PLANNING APPLICATION REPORT

REF NO: AB/75/10/

LOCATION: Chantry Cottage
36 King Street
Arundel

PROPOSAL: Proposed new north facing dormer window and removal of redundant unstable chimney stack

FIRST FLOOR PLAN & SECTIONS A-A&B-B
Job No. 637 Scale 1:50@A1, 1:100@A2 Date 14.06.10 Dwg. No. 401(B)

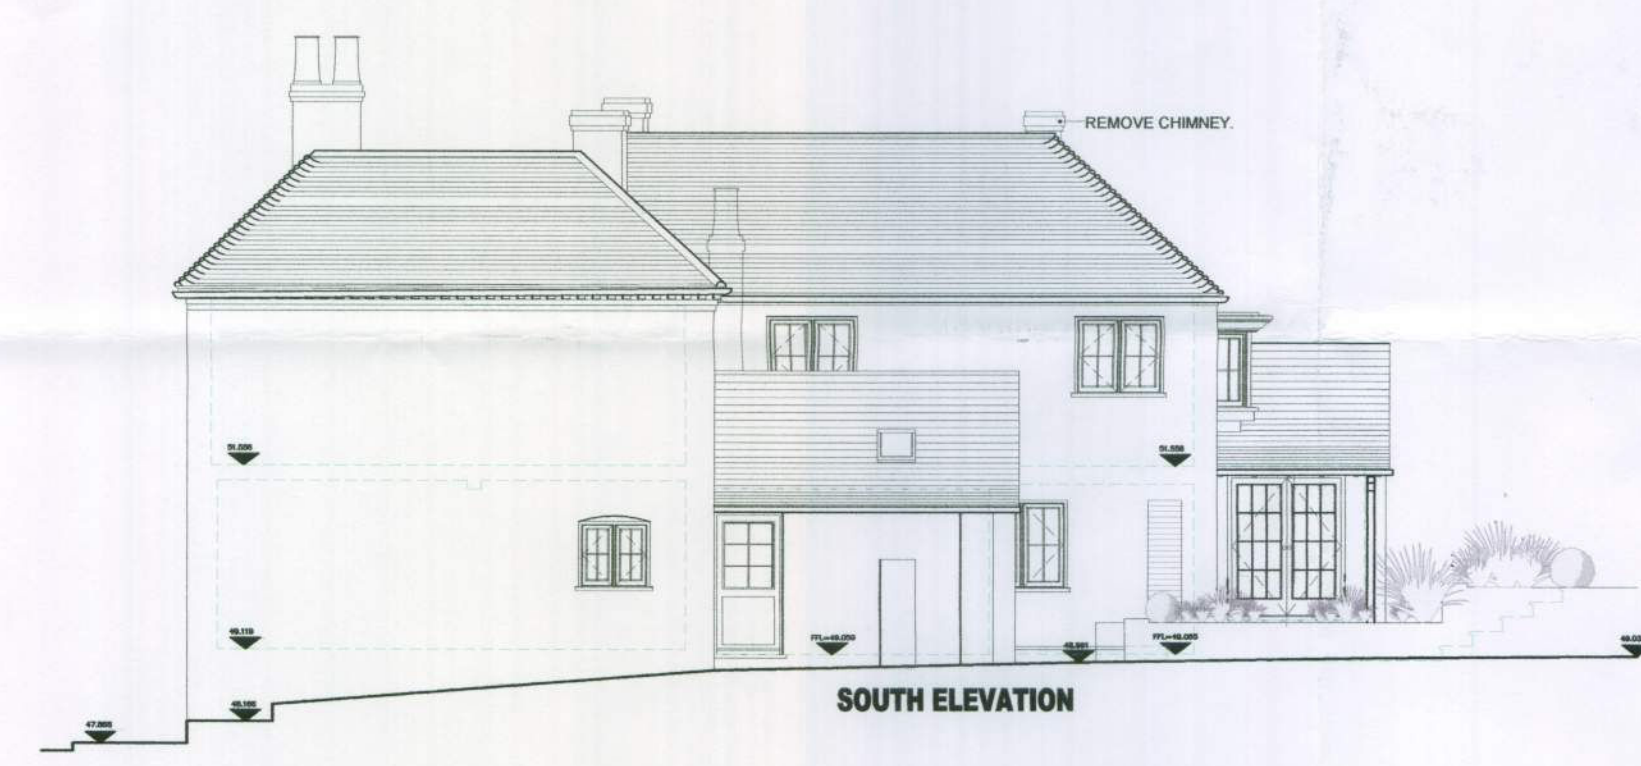
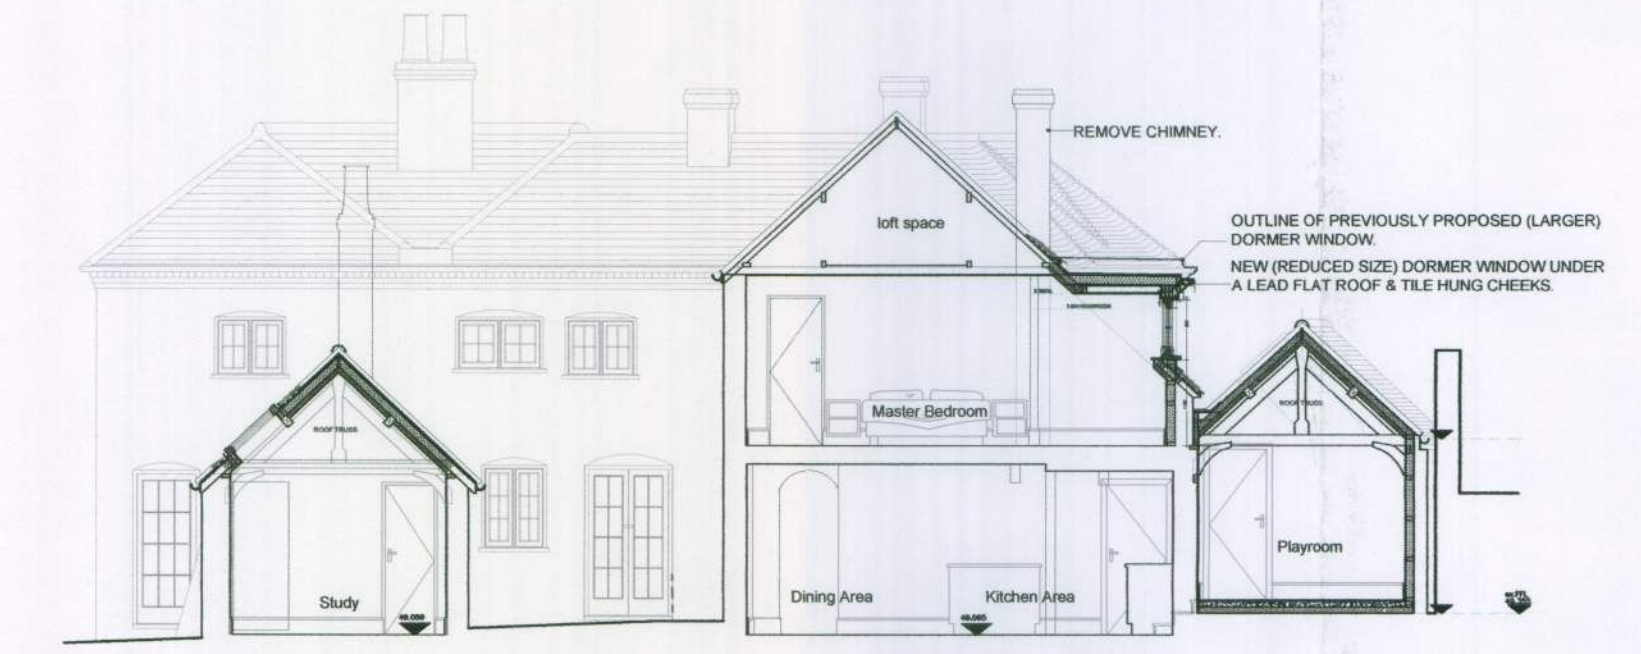
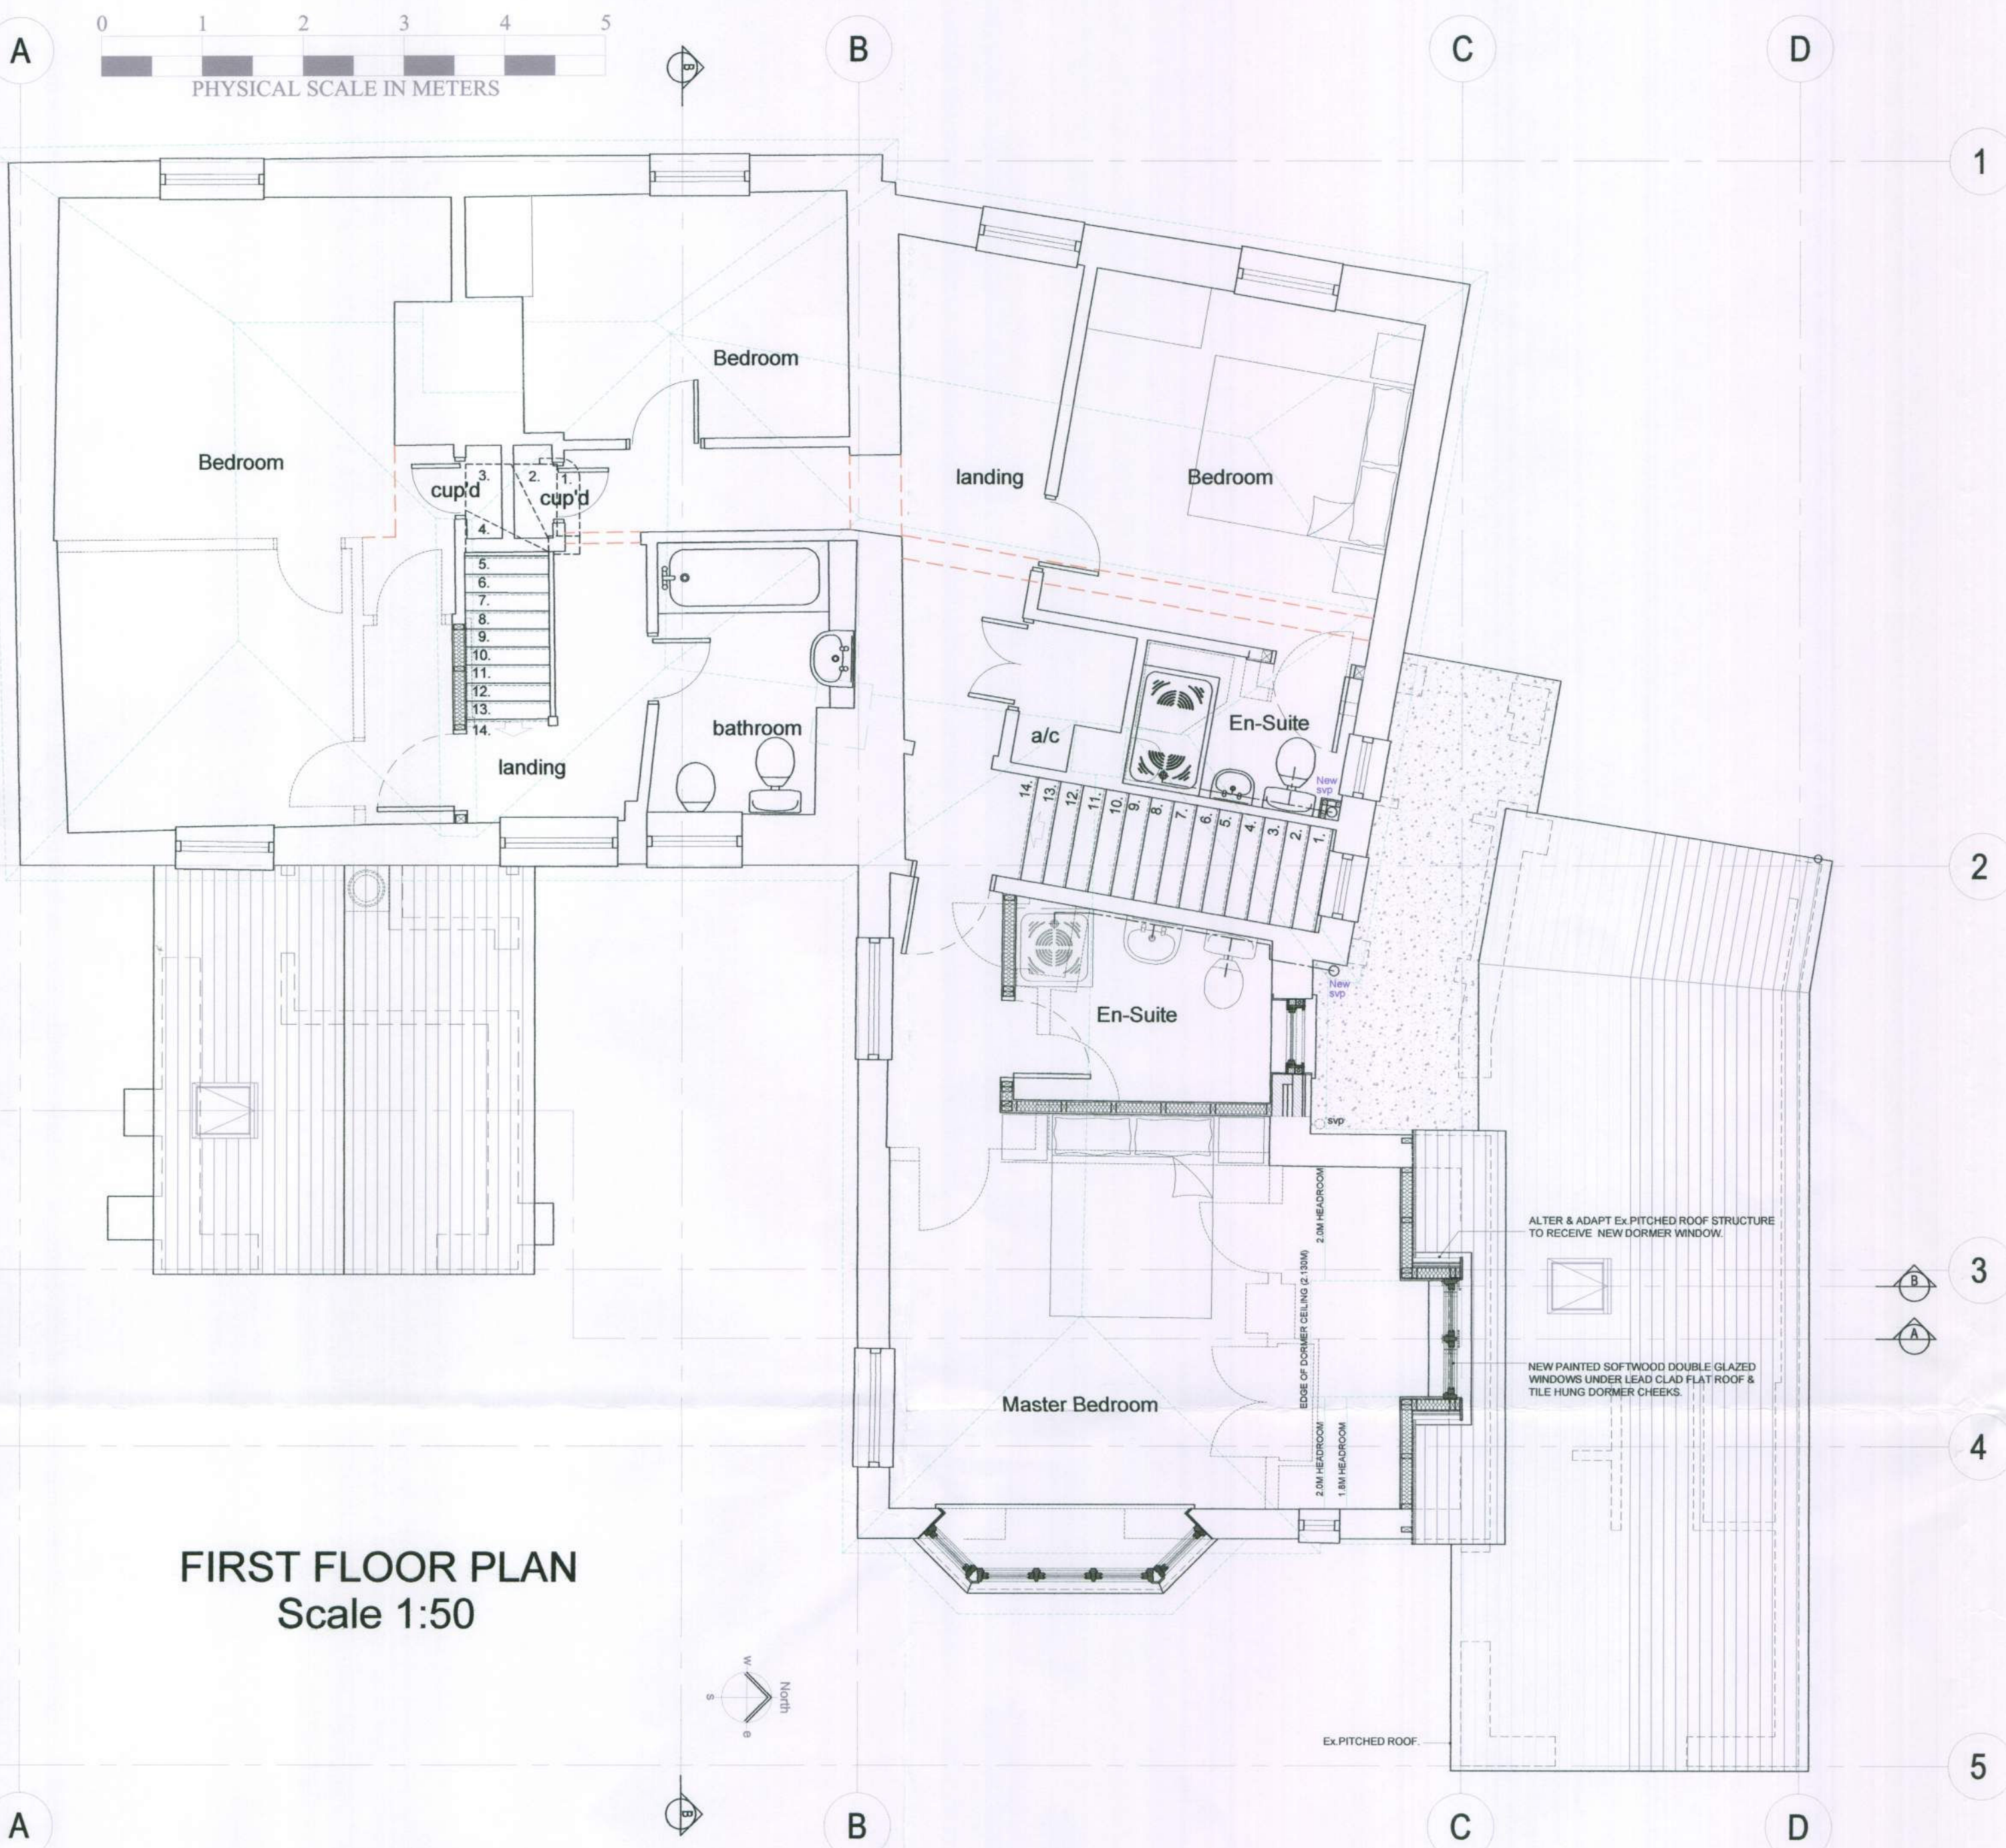
The proposal seeks consent for 1No. flat lead roof dormer and the removal of a redundant chimney to the northern (side) roof slope. It is noted that planning approval has previously been granted for a dormer window of an increased height, width and depth under planning reference AB/150/09/.

The proposed dormer by reason of its design together with its height, width and depth is not considered to detract from the appearance of the Listed Building and given that the dormer window would also be to a 1960's addition it would not impact upon the historic fabric of the Listed Building. The proposed dormer window would only be partly visible from the street scene and the grounds of the Cathedral to the north of the site.

The proposal to remove the chimney is considered to be acceptable as it is sited within the later addition of the building and therefore does not form part of the original building. The chimney is set back from the principle elevation of the building and is not prominent within the street scene. Also the building retains 3No. chimneys which are prominent within the street scene which minimises the impact of its removal.

- 3 The materials and finishes of the external walls and roof of the dormer window hereby permitted shall match in colour and texture those of the existing building.

Job No. 637 Scale 1:50@A1, 1:100@A2 Date 14.06.10 Dwg. No. 203(B)

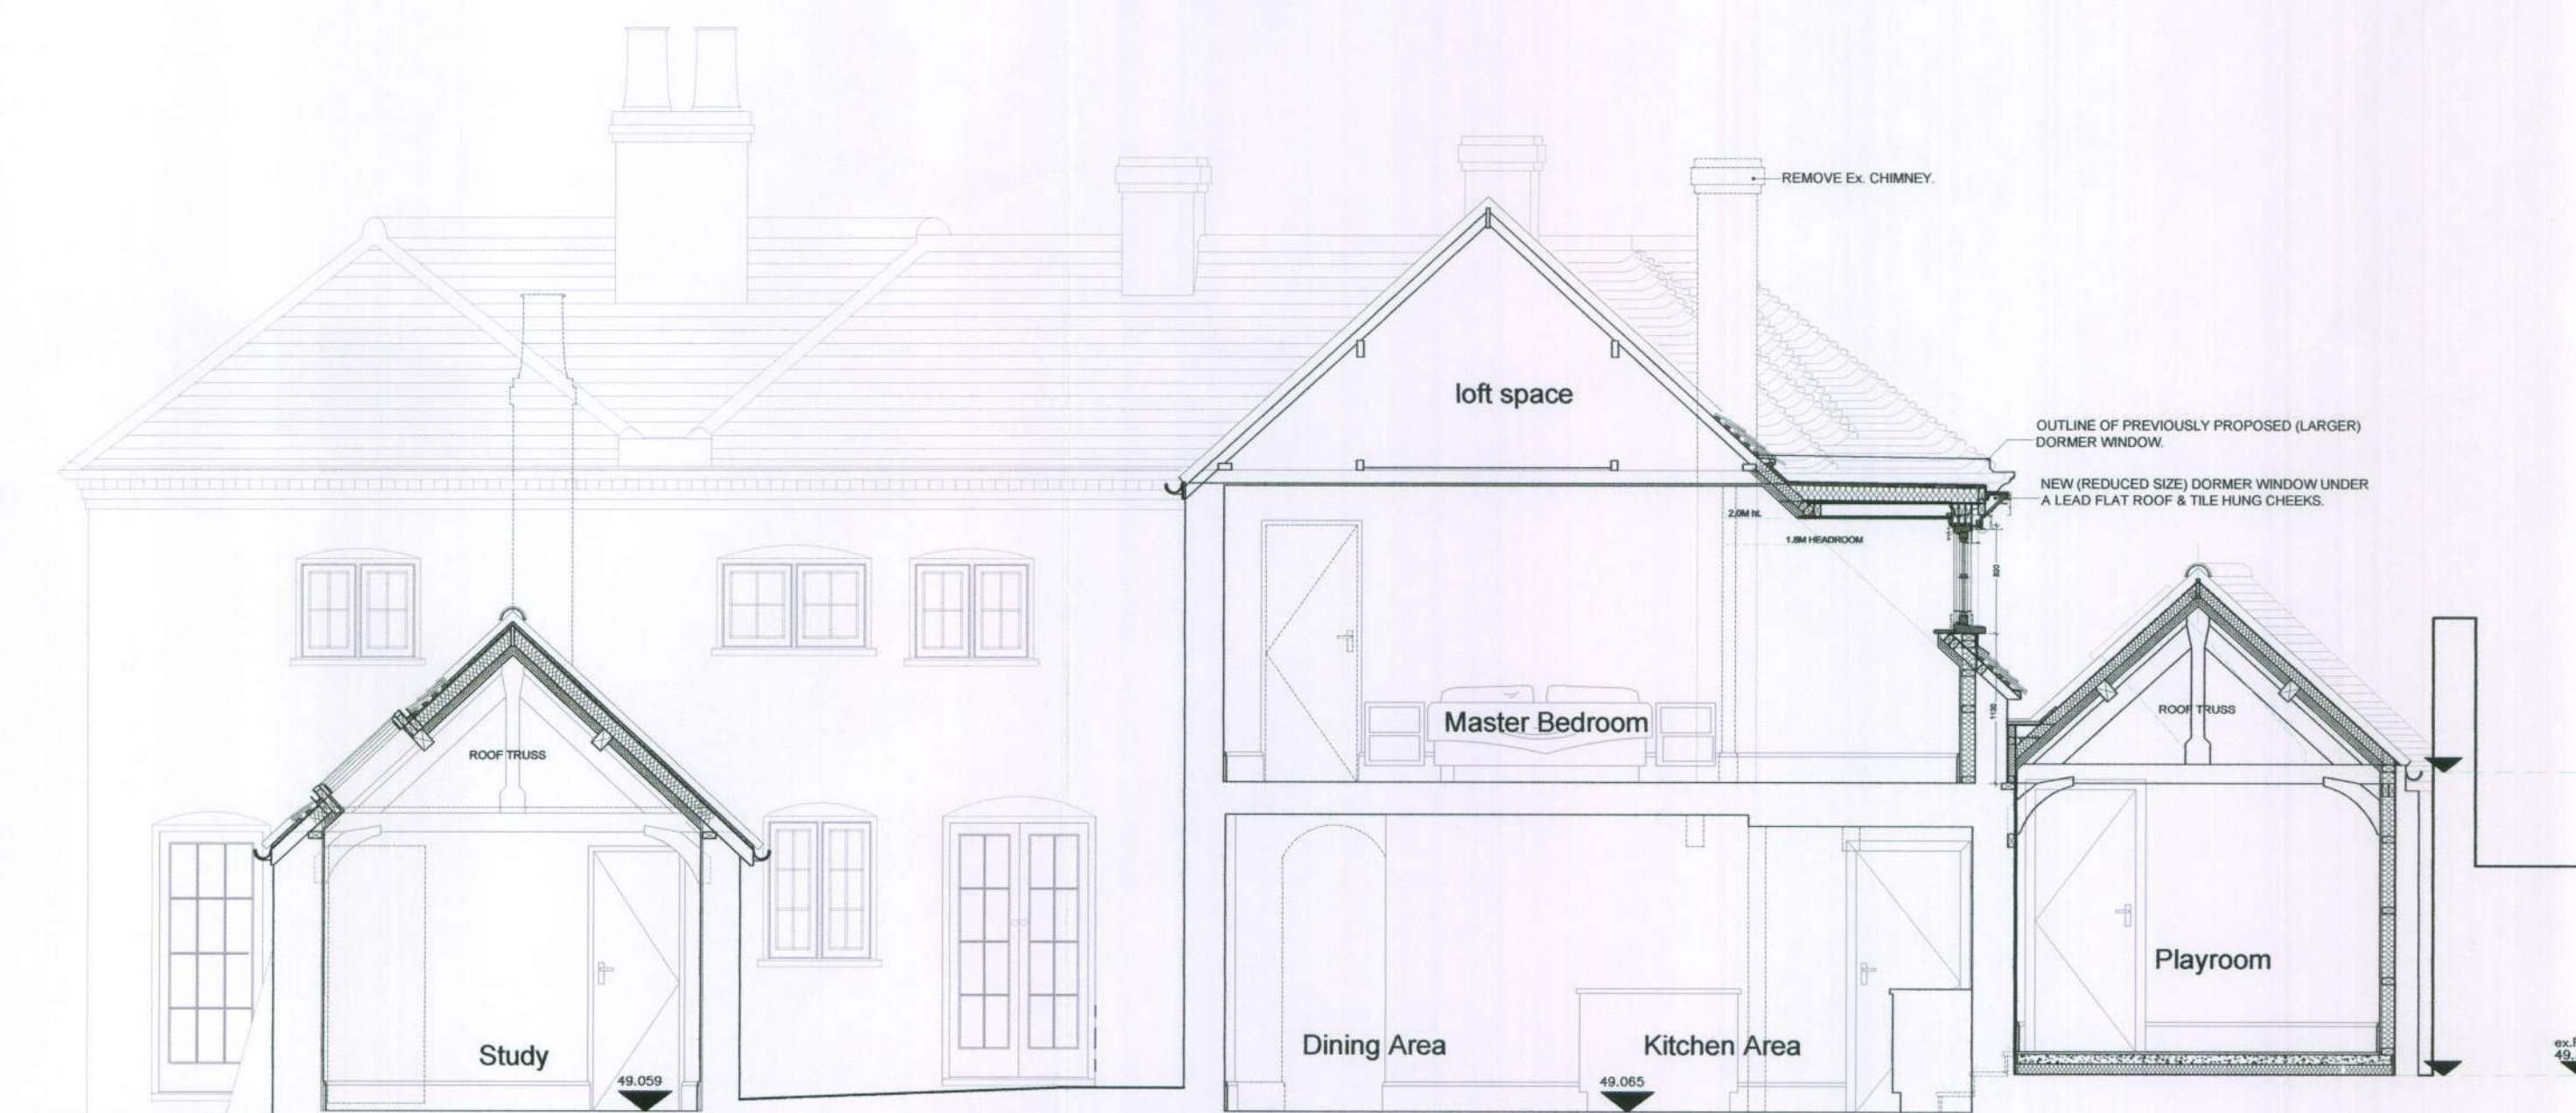
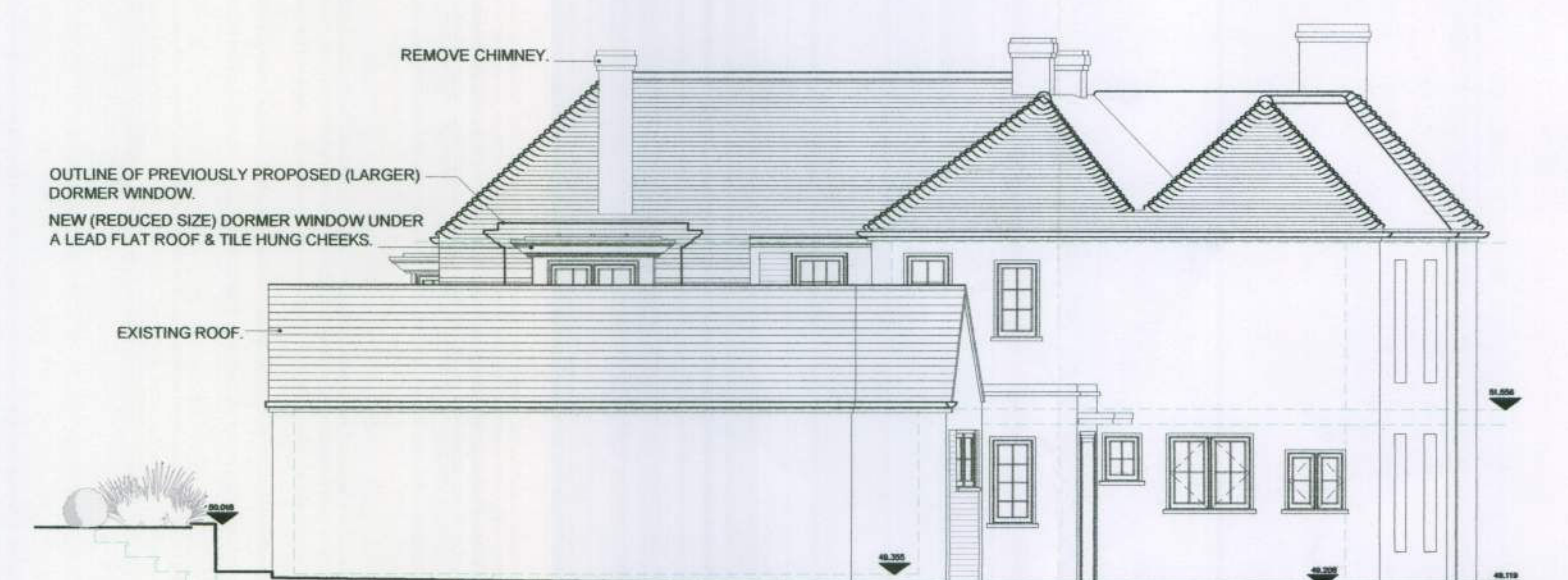
It is considered that the above mentioned works would not have an unacceptable adverse impact upon the street scene as the dormer window would be set low on the existing roof slope with its design relating sympathetically to the host dwelling. Further, the roof slope of the existing single storey side extension would also significantly reduce its impact.
